A303 Sparkford to Ilchester Dualling Scheme TR010036

8.3 Draft Statement of Common Ground with Historic England

DRAFT STATEMENT OF COMMON GROUND

This Statement of Common Ground has been prepared and agreed by (1) Highways England Company Limited and (2) The Historic Buildings and Monuments Commission for England (HBMCE).

WORK NO.92 HAZLEGROVE SCHOOL ACCESS

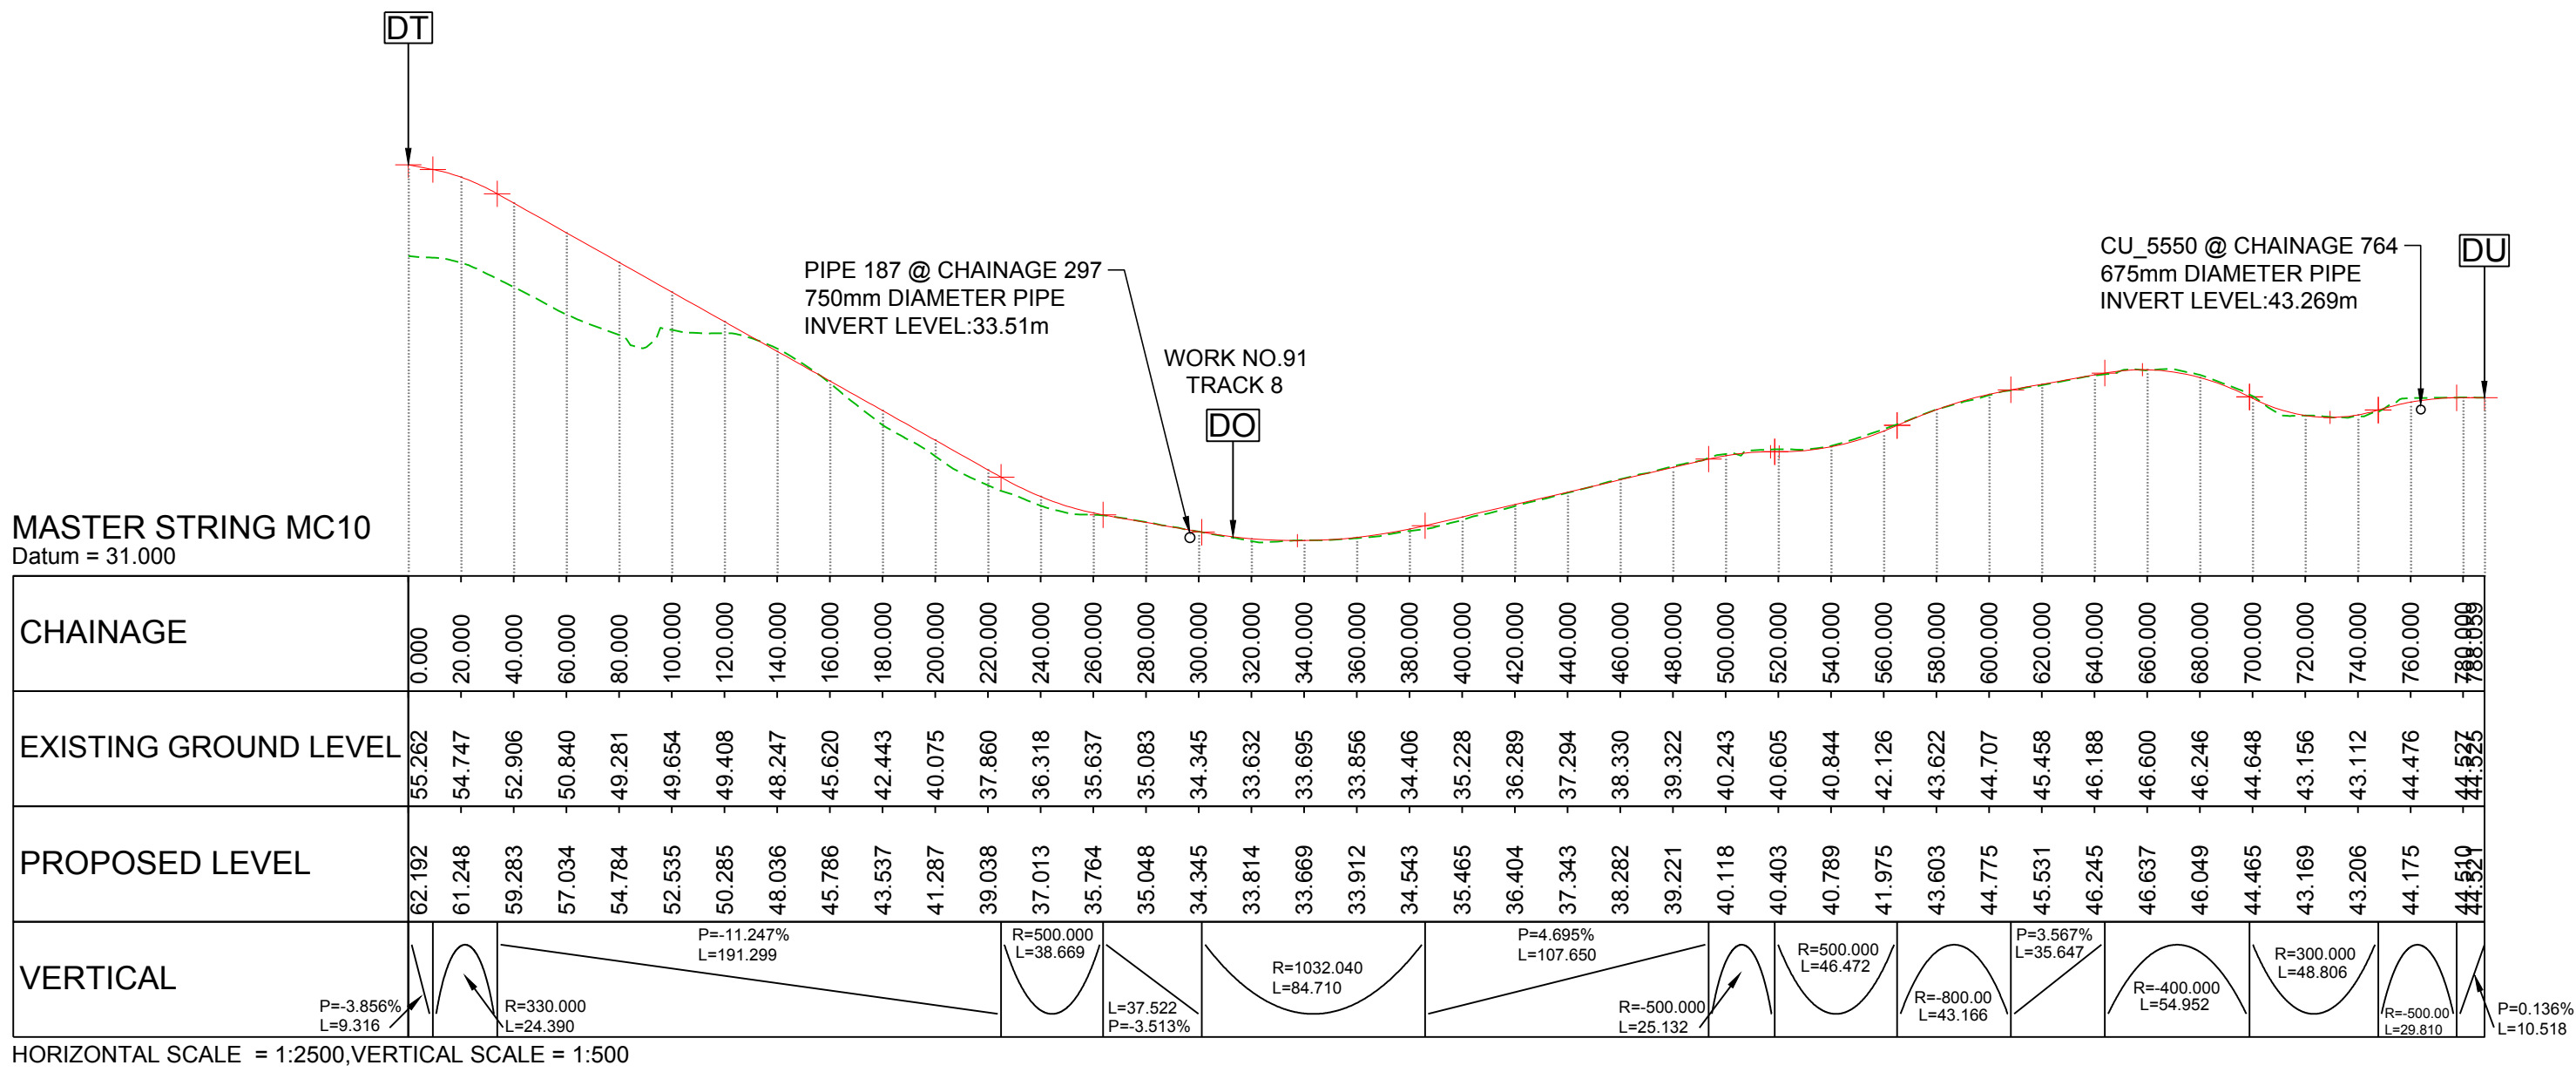
Topic	Sub-section	Historic England comment	Highways England response	Status
			(OEMP) (document reference 6.7, Volume 6, Rev A).	
		Access road to Hazlegrove School should respond to the topography and historic character of the southern end of the park to create a new formal approach. The transition should be as swift and sympathetic as possible from engineered road to parkland setting.	Revisions to the layout of the pond, access track, fencing, school access and arrival point into the RPG are currently under discussion,	UNDER DISCUSSION
		A conservation management plan addressing the issues and management of the whole RPG should be prepared as part of the mitigation of the harm caused by the scheme to the RPG.	<p>If a conservation management plan is prepared as part of the DCO it will only be able to address works which directly mitigate the scheme, rather than be a holistic document which allows for the long-term management of the complete RPG.</p> <p>Within row CH10 of Table 3.1 (REAC) in the revised draft of OEMP to be submitted to the Examination at Deadline 5 (document reference 6.7, Volume 6, Rev A) the following provisions have been put in place;</p> <p><i>“The landscape scheme at Hazlegrove House RPG including screening, landscape planting, erection of fences, surfacing and appearance of the balancing pond should reflect the parkland character of the RPG. This includes location of planting and species to be used. SSDC, The Gardens Trust and Historic England will be consulted on the landscaping scheme including maintenance, prior</i></p>	UNDER DISCUSSION
